Our Ref: FG/145/19/PL
Your Ref:

Town & Country Planning Act 1990 (as amended)
Town and Country Planning (Development Management Procedure) (England) Order 2015
Application for Planning Permission

Development	Demolition of existing detached dwelling and replace with new two storey detached dwelling.
Location	31 South Drive Ferring

Drawing Title
**Replacement dwelling
Roof void.**

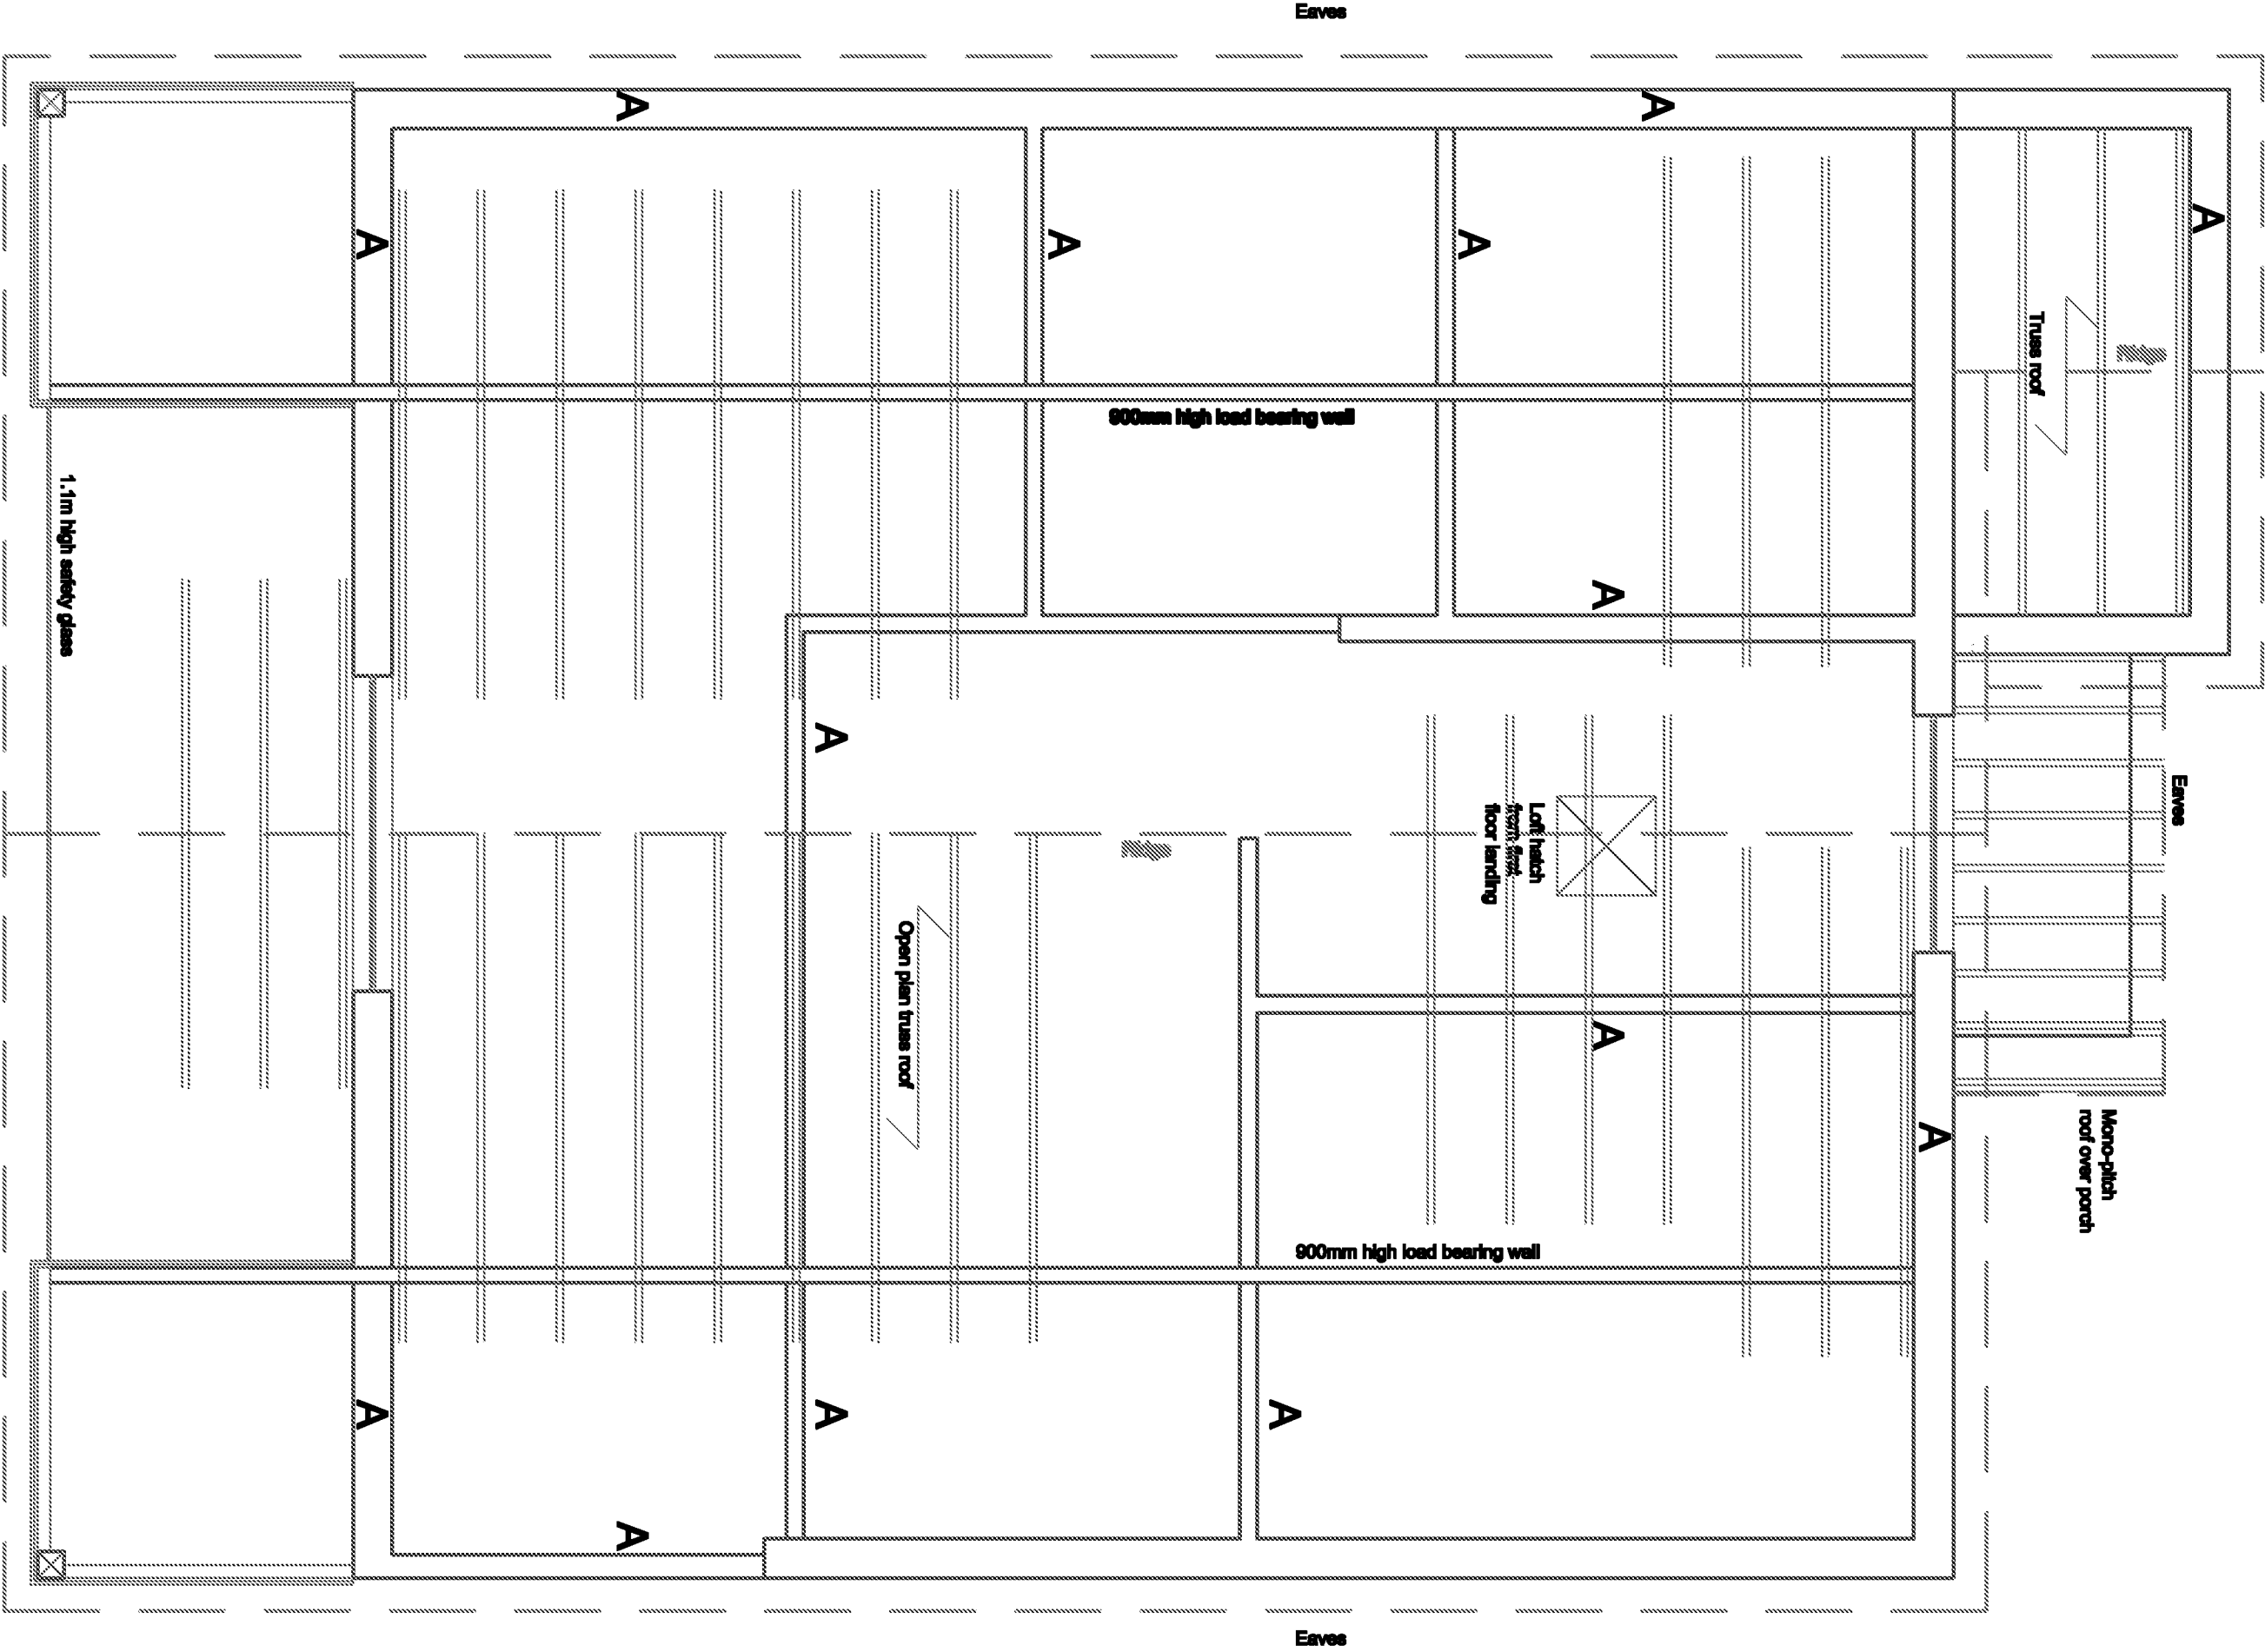
Floor Plans

Please submit proposed floor plans for the 2nd floor/loft. These should be drawn to a scale of 1:50 or 1:100.
